## Department of Primary Industries

OUT15/30428

**Eagleton Hard Rock Quarry (SSD\_7332)  
Request for input into Secretary's Environmental Assessment Requirements**

Figure 3 – Site Characteristics and Features
Source: Eagleton Rock Syndicate

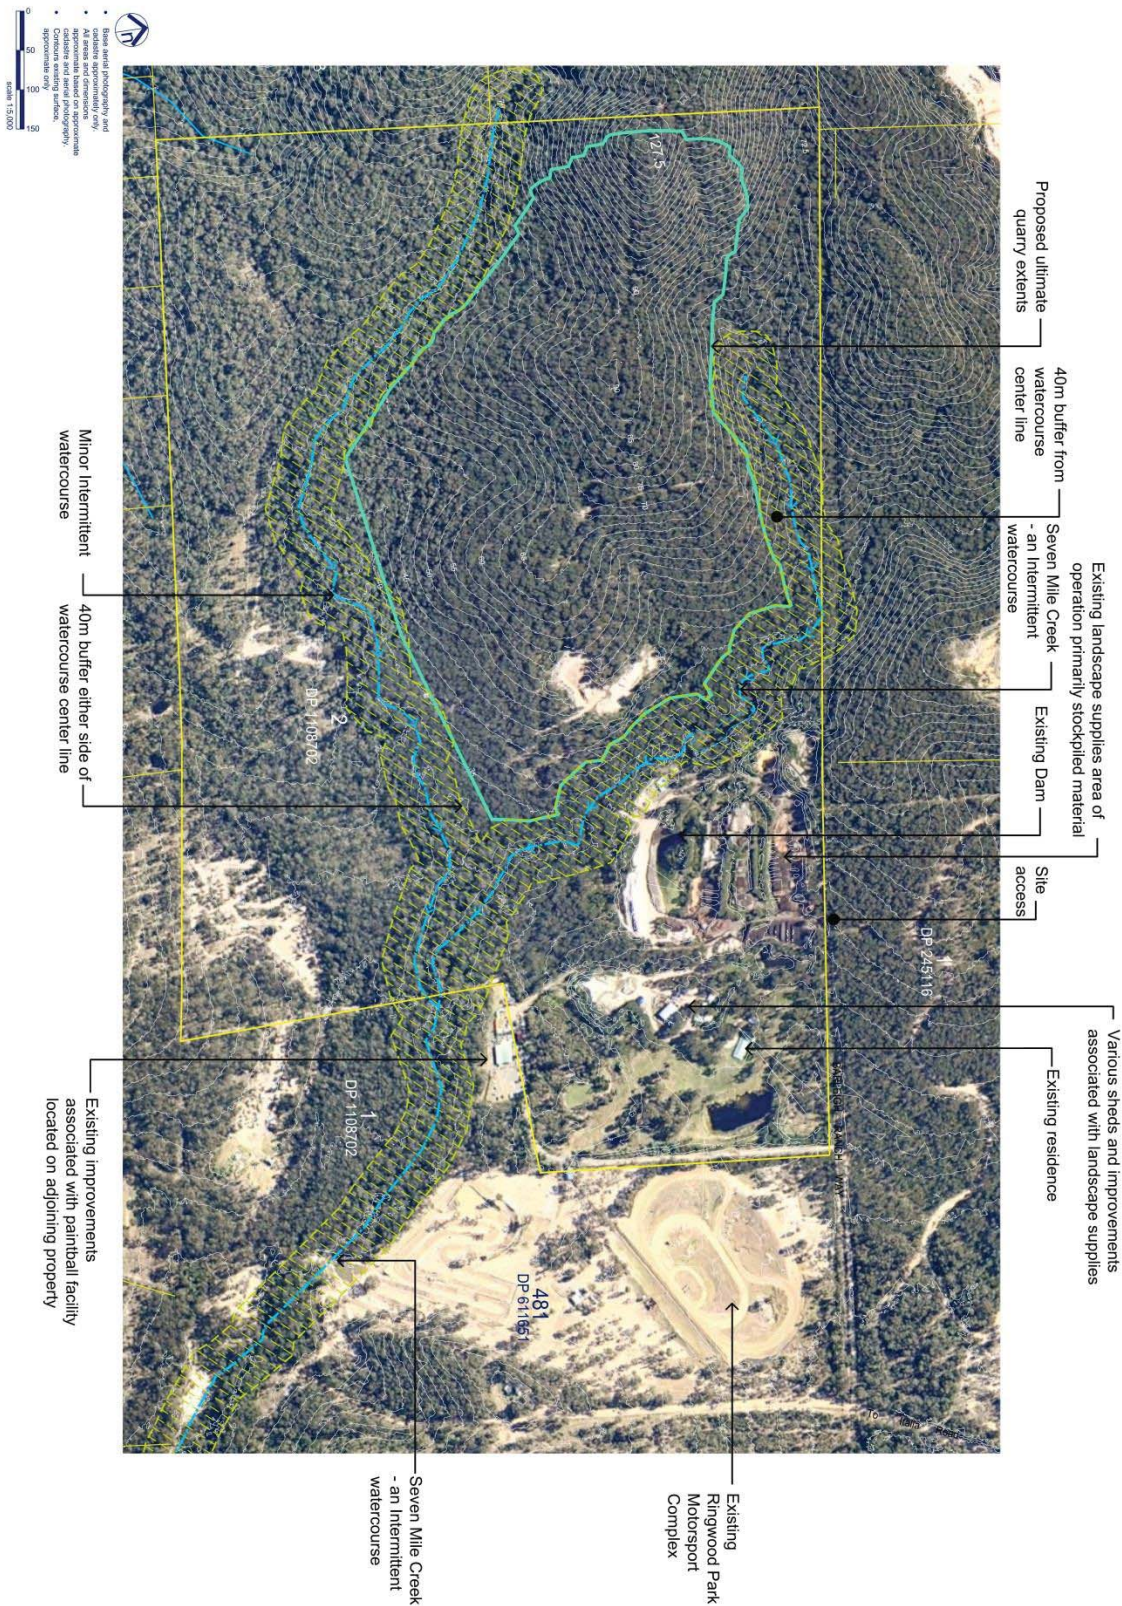
Additionally although state significant developments are exempt from requiring a controlled activity approval, DPI Water Guidelines for works on water front land should still be followed. It is noted that in Figure 3 the water course buffers have been measured from the water course centre line. The proponent must be aware

that buffers for the vegetated riparian zones must be measured from the highest bank of the water course and not the centre line. The relevant guideline is the "*Guidelines for Riparian Corridors on Waterfront Land*" which can be accessed at the following link:
